Final Report - Corrections Required **Application No. PDZD-26-0017**

Description : PDZ Development Plan for the Paint Mines at Reagan Ranch comprised of 102 single-family attached residential lots on 15.283 acres.

Record Type : PDZ Development Plan

Document Filename : Paint Mines at Reagan Ranch PDZ DP_1st Submittal.pdf

DT01
SHEET 2 OF 15
CITY FILE NO.: PDZD-XX-XXXX

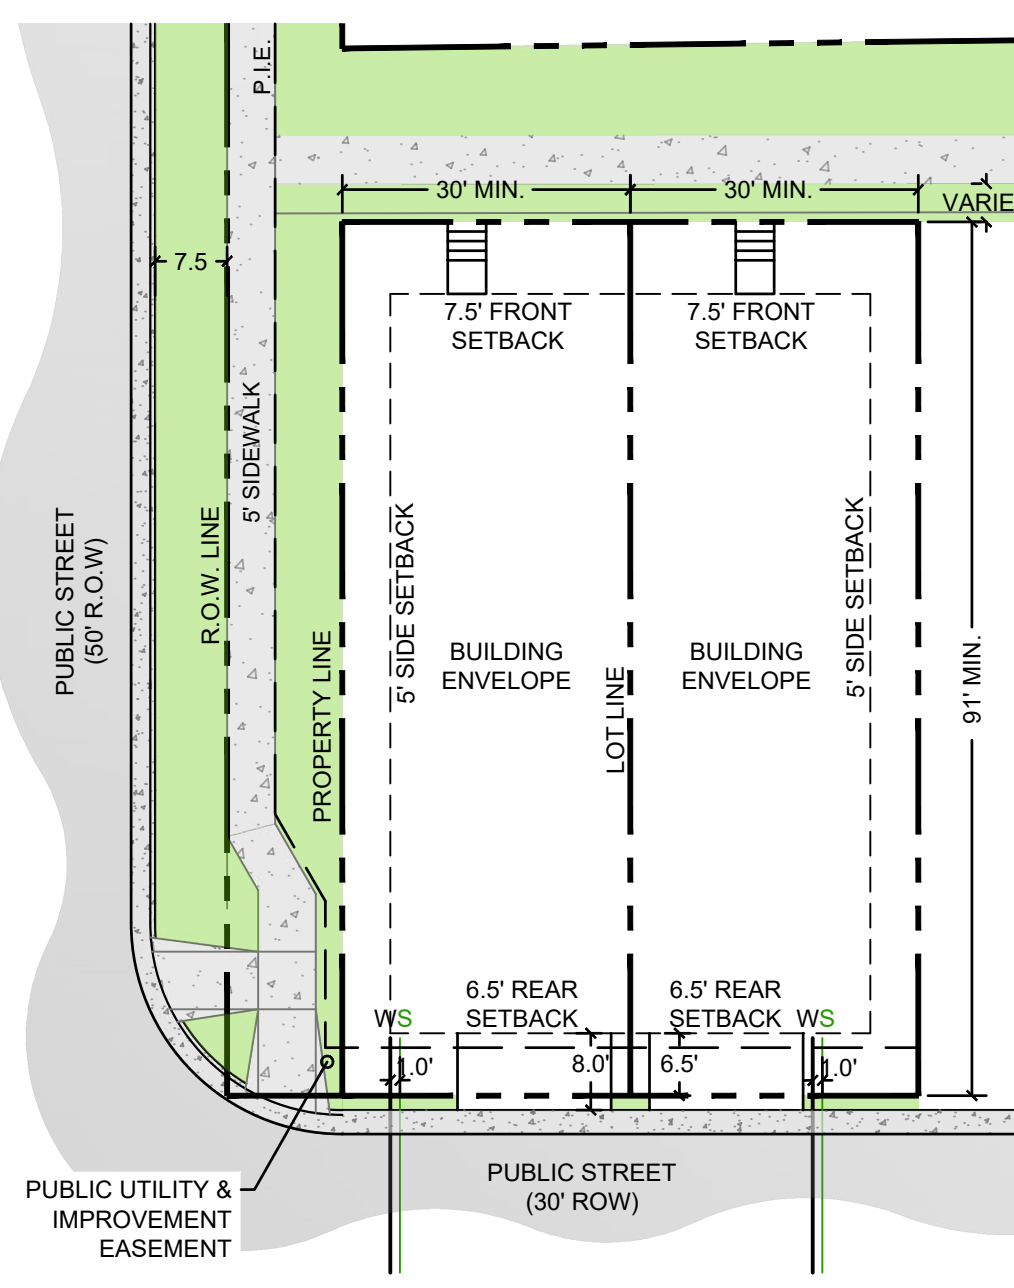
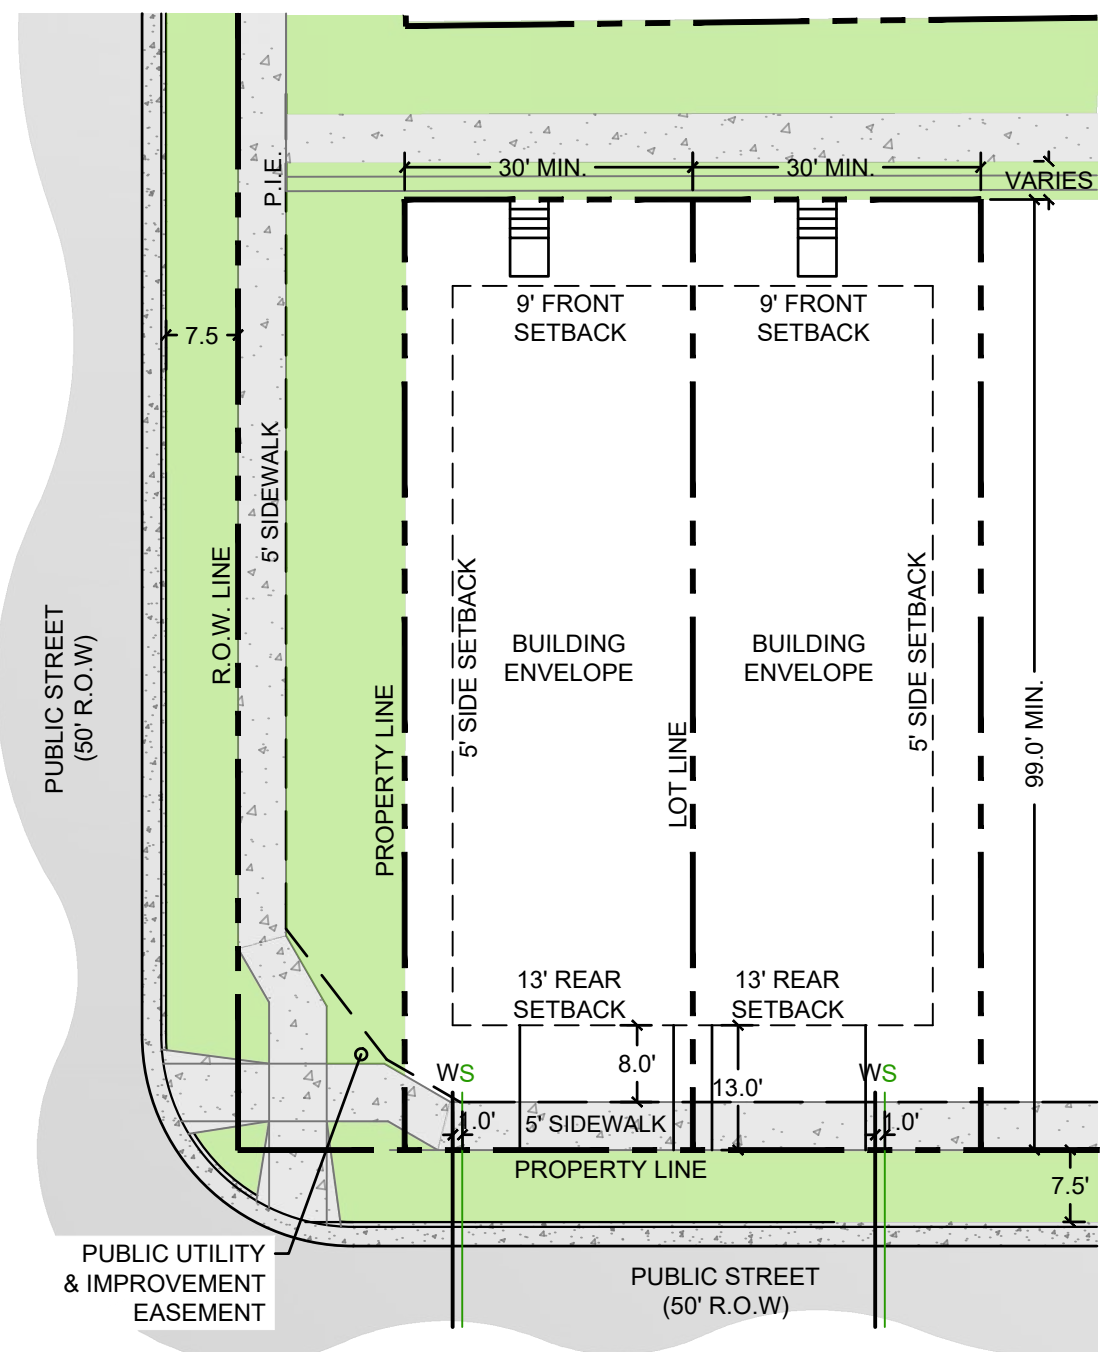
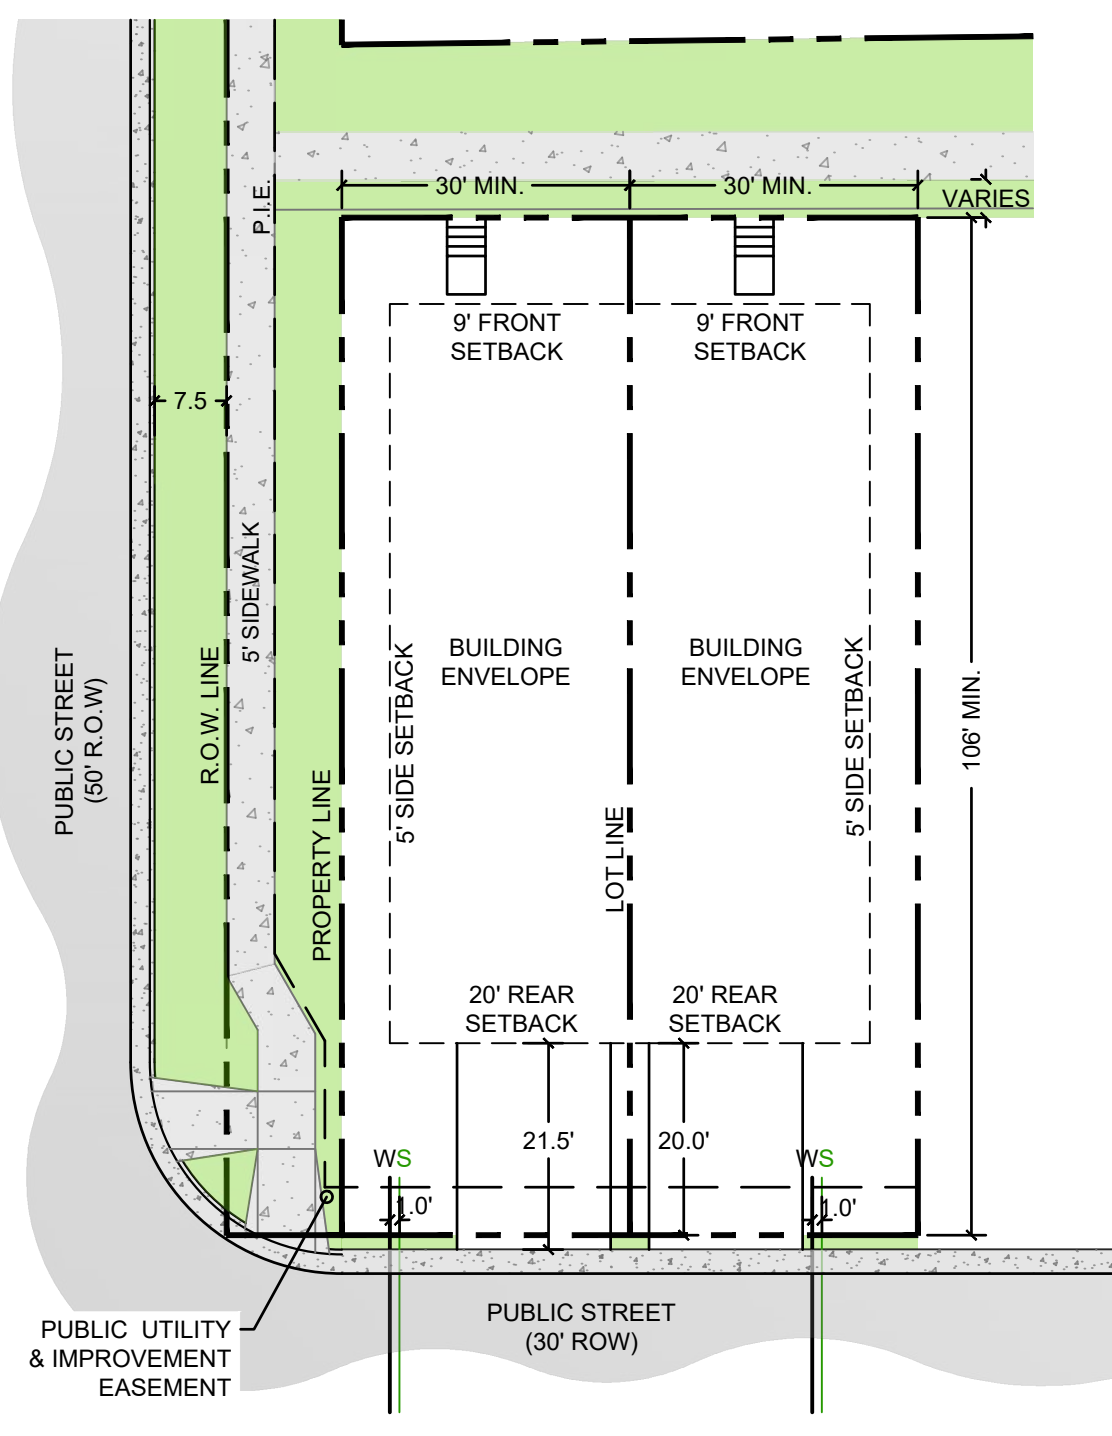
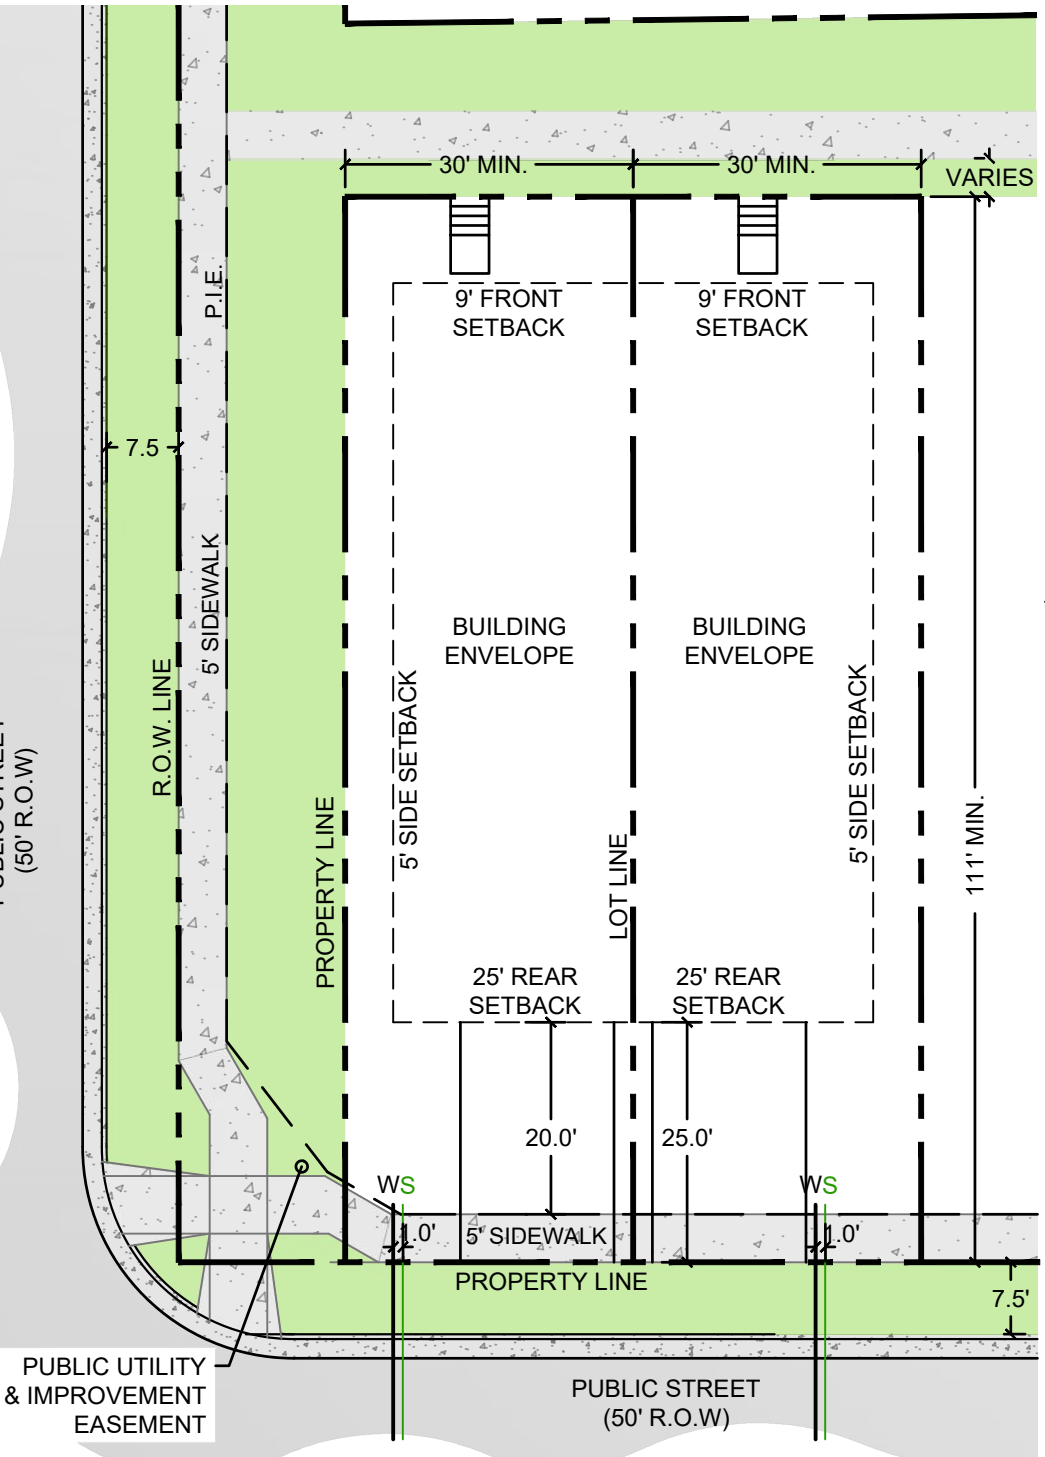
33	1	Patrick Dosch : Col Springs Utilities	Please upload the HGL response form
34	2	Patrick Dosch : Col Springs Utilities	Show or reference A3-10 from the WLESS
35	2	Patrick Dosch : Col Springs Utilities	Show A3-8 (50' ROW) or another approved street cross section from the LESS. Please show all proposed utility configurations in the street cross section
36	2	Patrick Dosch : Col Springs Utilities	Add note "CSU Field Engineer to determine final gas/electric meter, transformer, and service line locations. Contact Field Engineering at 719-668-4985 (Gas) or 719-668-5564 (Electric) with any questions."
37	2	Patrick Dosch : Col Springs Utilities	Add note: " Gas meters must be a minimum of 3-feet from doors, operable windows, or any vents or openings in walls."
38	2	Patrick Dosch : Col Springs Utilities	Gas and electric meter locations need to be shown and labeled on lot typical diagrams. Please also show the curb stop and indicate the horizontal separation from building and sidewalk (trench).

39	2	Patrick Dosch : Col Springs Utilities	Info Only: Per GLESS 4.05.d.3.a. for new residential construction, Gas meter shall be placed 5' from front corner of building.
40	8	Patrick Dosch : Col Springs Utilities	Please indicate proposed material for water and wastewater mains , typical
41	9	Patrick Dosch : Col Springs Utilities	Please label as a HS-20 Access road
42	9	Patrick Dosch : Col Springs Utilities	Proposed detention pond is shown within existing easement. Please revise the location.

SP01

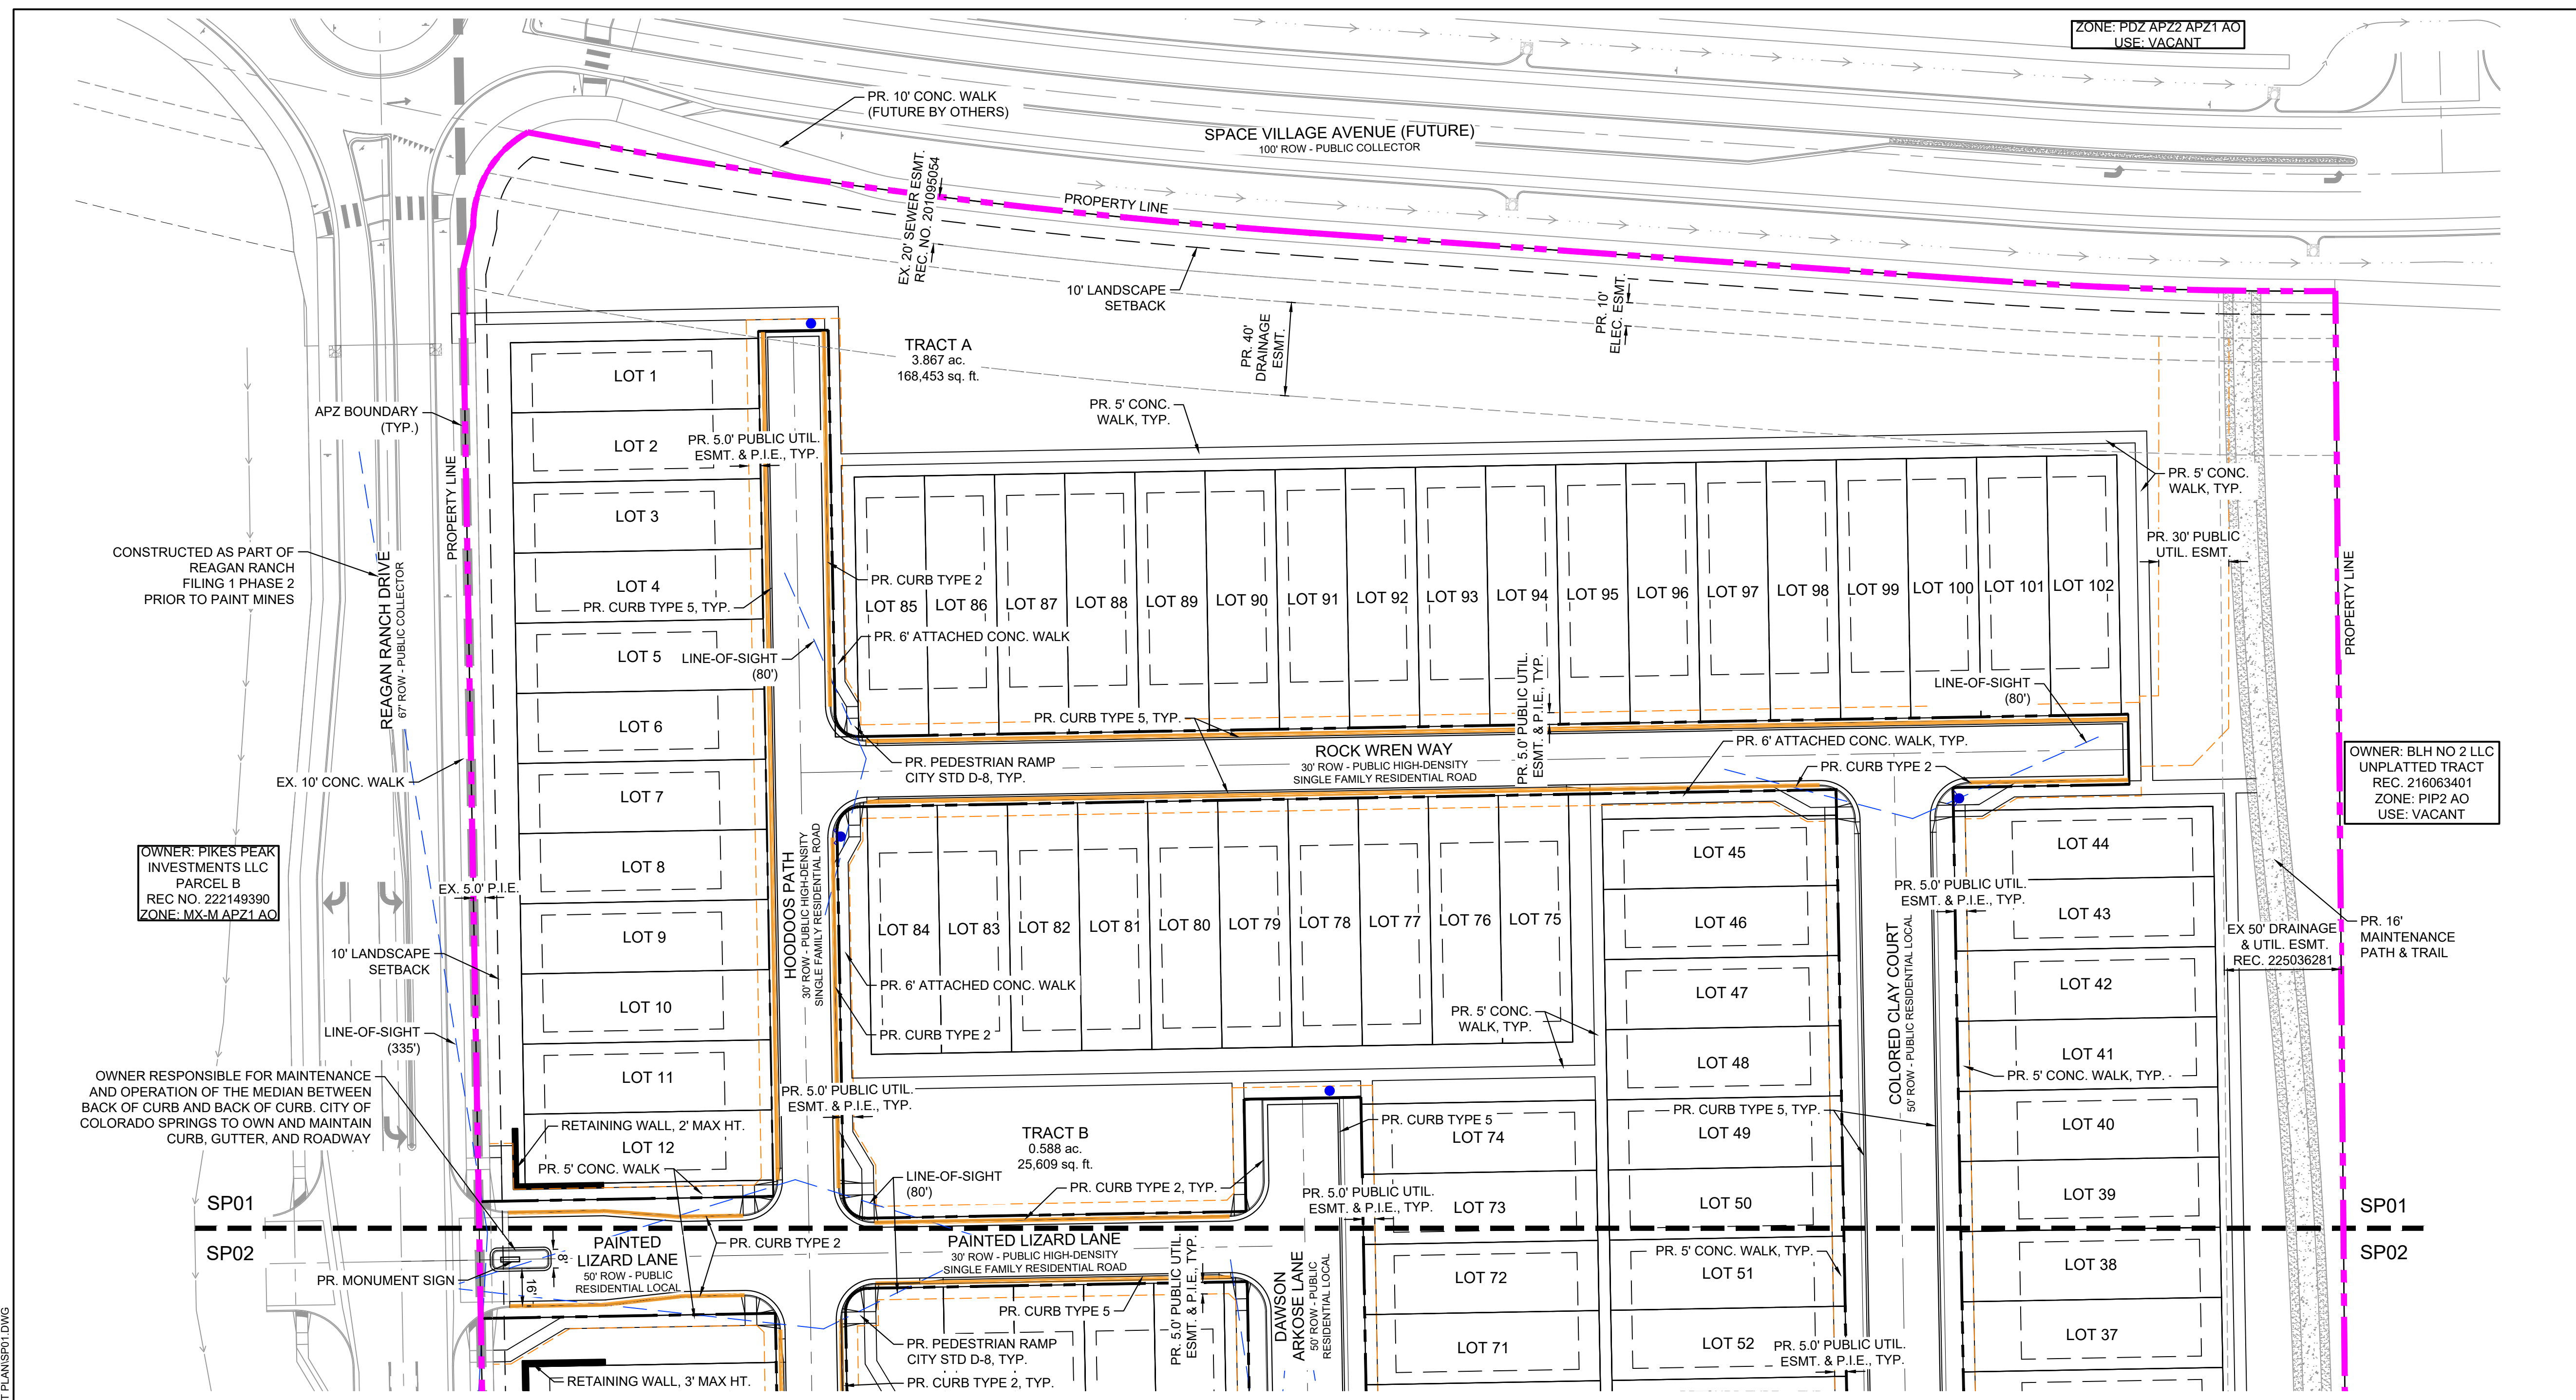
Comment ID	Page Reference	Reviewer : Department	Review Comments
65	9	Sara Rivera : City Engineering - SWENT	Will this portion of the street be constructed with this development? If so, make this clear in the DP.
6	1	Hao Vo : City Engineering Dev Review	Please contact USPS at coloradospringsgrowthmanagement@usps365.onmicrosoft.com directly to review this development for mail service. To establish mail delivery and kiosk locations an appointment will be required with USPS to determine final locations. Information required for this establishment include proposed locations, type of mail receptacle, final plat with addresses, type of development (residential/commercial) and date of first occupancy
12	4	Hao Vo : City Engineering Dev Review	Please clarify who will be responsible for constructing the sidewalk and C&G on Space Village Ave and provide the expected timeline.
25	4	Hao Vo : City Engineering Dev Review	Please call out C&G on Space Village

26	4	Hao Vo : City Engineering Dev Review	Please call out C&G on Reagan Ranch
27	4	Hao Vo : City Engineering Dev Review	Info Only: EDRD mandates the removal and replacement of all public sidewalks, curbs, gutters, pedestrian ramps, and similar infrastructure during development if they are in poor condition or do not meet current standards.
28	4	Hao Vo : City Engineering Dev Review	Info Only: Construction drawings are required for review and approval prior to construction.
29	4	Hao Vo : City Engineering Dev Review	Please clarify whether the sidewalk at the back of the lot is private or public.
24	7	Hao Vo : City Engineering Dev Review	RPA within public ROW is not allowed. Please remove it.
32	1	Patrick Dosch : Col Springs Utilities	Please contact CSU UDS Staff to schedule a Pre-DP approval meeting with the gas and electric field engineering teams (high density residential proposed). Patrick - pdosch@csu.org

Comment ID	Page Reference	Reviewer : Department	Review Comments
17	4	Michelle Lavelle : Planning	Need replace Hoodoos Path - Street name is not available.
74	4	Caroline Miller : Planning	Please call out walkway as East Sand Fork Creek Urban Trail
80	4	Allison Stocker : Planning	Sidewalk connection here?
81	4	Allison Stocker : Planning	Sidewalk connection here?
84	4	Allison Stocker : Planning	Per Section 7.4.203, PDZ's are required to have sidewalks on both sides of public streets
82	5	Allison Stocker : Planning	Will there be a cross-walk or other pedestrian protections for the trail crossing?
83	5	Allison Stocker : Planning	Is there a sidewalk along the north side of Horn Base Avenue? I am not seeing one
75	10	Caroline Miller : Planning	This site vicinity graphic is incorrect. Please revise.
18	12	Gregory Stachon : Planning	Please show a compact lot tree on the lot typical and indicate which lots are "street-oriented lots" that require them on the plan
